Located At 1854 FOREST AVE

Job ID: 2011-06-1396-ALTCOMM

has permission to Phase 1. Change the Use from a community hall to karate center, basement & 1st flr, 2nd floor vacant provided that the person or persons, firm or corporation accepting this permit shall comply with all of the provisions of the Statues of Maine and of the Ordinances of the City of Portland regulating the construction, maintenance and use of the buildings and structures, and of the application on file in the department.

Fire Comments

**1 BASEMENT LIFE SAFETY PLAN**  
 LS1 SCALE 1/4" = 1'-0"

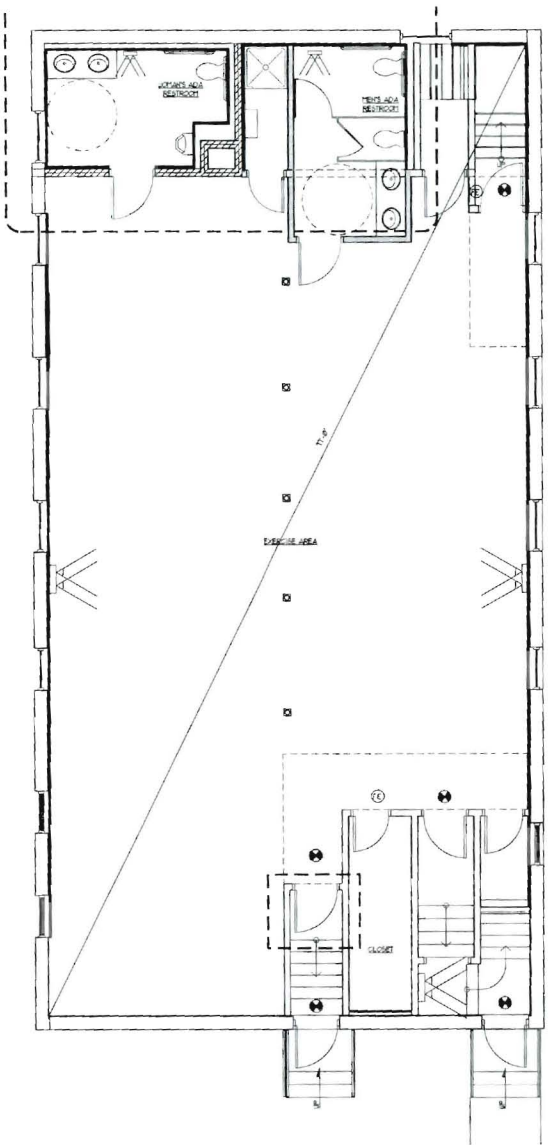
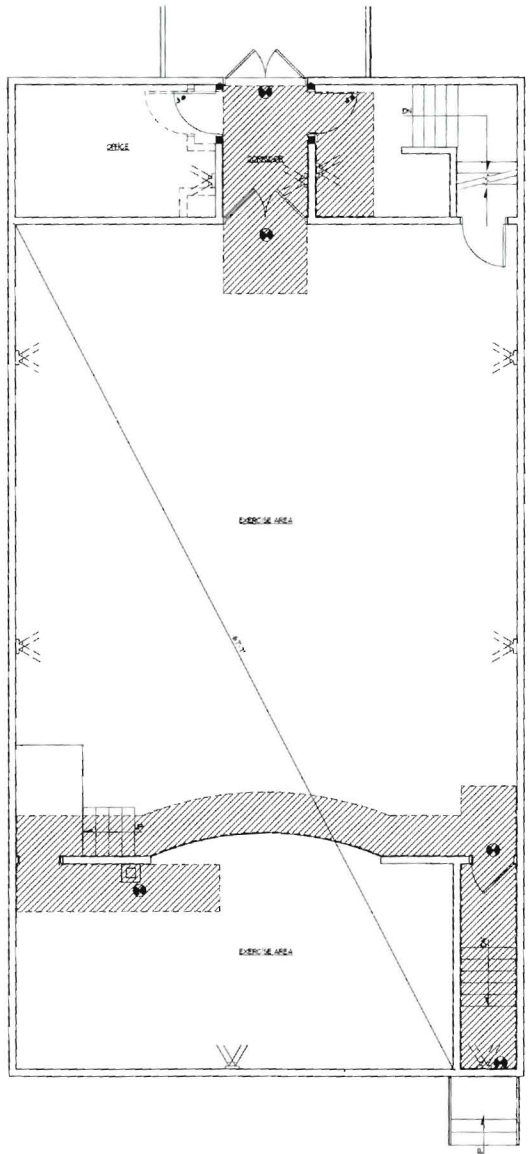
The stair between the basement and first floor has dueling doors between the basement and bathroom doors. It's not a required exit from the basement, but it is from the first floor.

The rear exit from the basement does not need to be enclosed. It does not penetrate floors, but only climbs a few steps and exits directly outside at grade.

**1854 FOREST**  
1847 FOREST AVENUE, PORTLAND, ME 04103  
**BASEMENT & FIRST FLOOR PLANS**

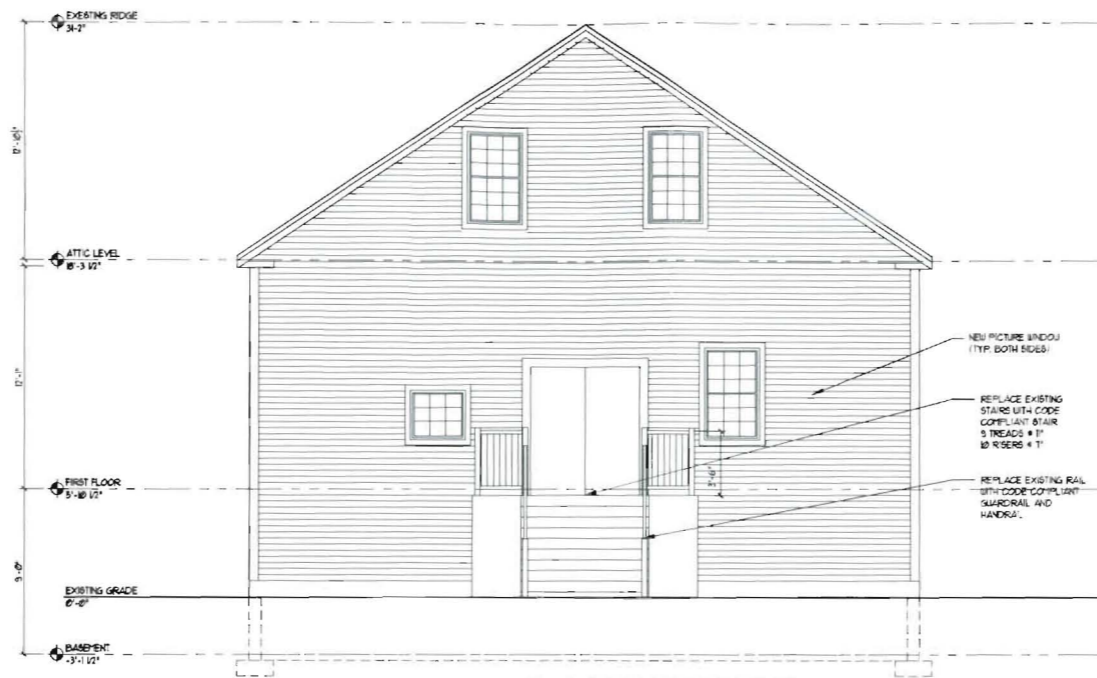
1. Application approval based upon information provided by applicant with revisions dated 6/23/11 and 6/28/11. Any deviation from approved plans requires separate review and approval prior to work.
2. Permit approved based on the plans submitted and reviewed w/owner/ contractor, with additional information as agreed on and as noted on plans.
3. All penetrations through rated assemblies must be protected by an approved firestop system installed in accordance with ASTM 814 or UL 1479, per IBC 2009 Section 713.
4. Separate permits are required for any electrical, plumbing, sprinkler, fire alarm, HVAC systems, heating appliances, including pellet/wood stoves, commercial hood exhaust systems and fuel tanks. Separate plans may need to be submitted for approval as a part of this process.
5. A water fountain is required for this use, primed floor drains required in the bathrooms.
